From: Lewis, Trevor <Trevor.Lewis@lancashire.gov.uk>
Sent: 14 May 2014 10:35
To: Colin Sharpe
Cc: planning; ENV LHS Customer Service
Subject: 3/2014/0288 Lamb Roe Sabden

The establishment of two separate dwellings on this site, where previously there has been one dwelling + granny flat, would result in the following requirements.

PROPOSED GRAMMAR SCHOOL  
6 LAMB ROW  
SADDEN

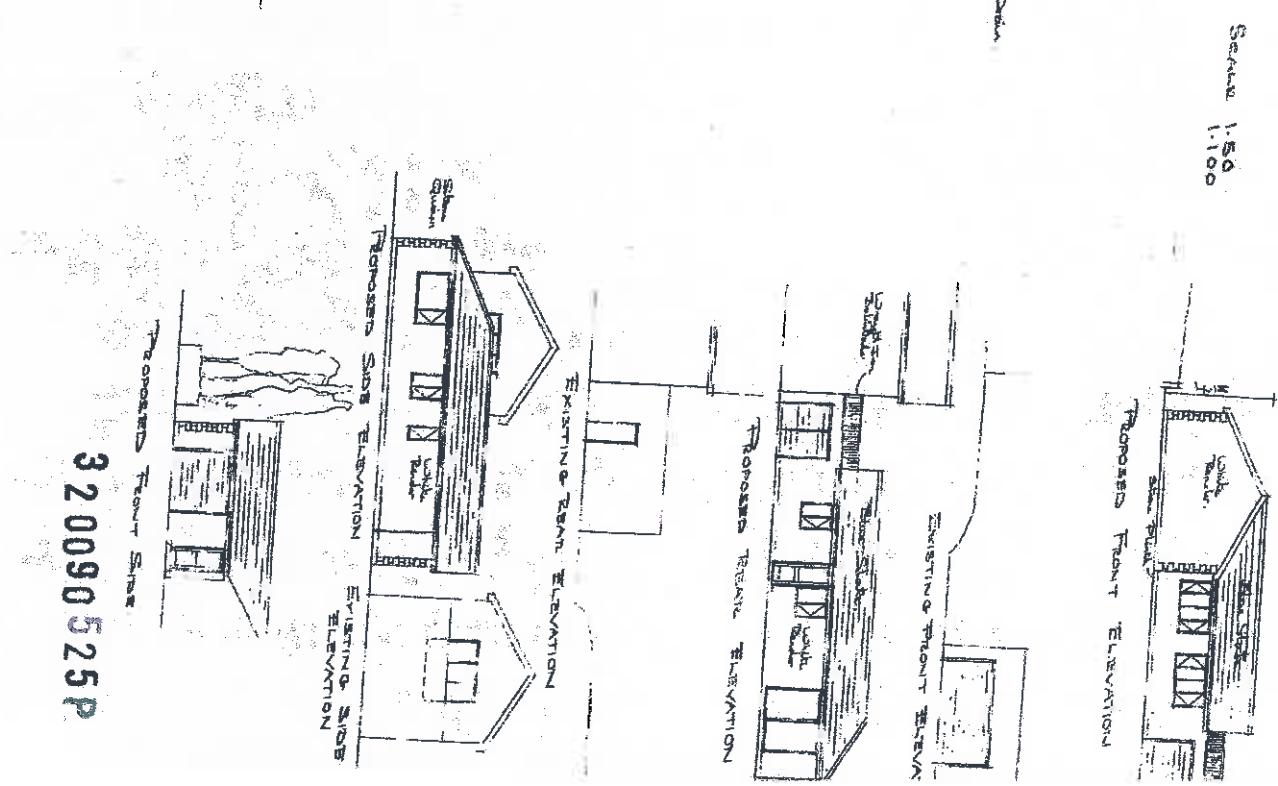
1. Two on-site parking spaces are required for each dwelling. There appears to be sufficient room within the site to accommodate the parking spaces. However, please ask the developer to provide a drawing showing the location of the two parking spaces for each dwelling.
2. The access into the site should be a minimum of 4.5m wide, which I understand is already provided.
3. If the gate is to be retained it should be set back at least 5m from the highway boundary, or removed.
4. Vehicles should be able to turn around within the site and drive out in forward gear.
5. The first 5m of the drive measured from the highway should be surfaced in a bound material or similar, to avoid loose material being carried on to the highway.
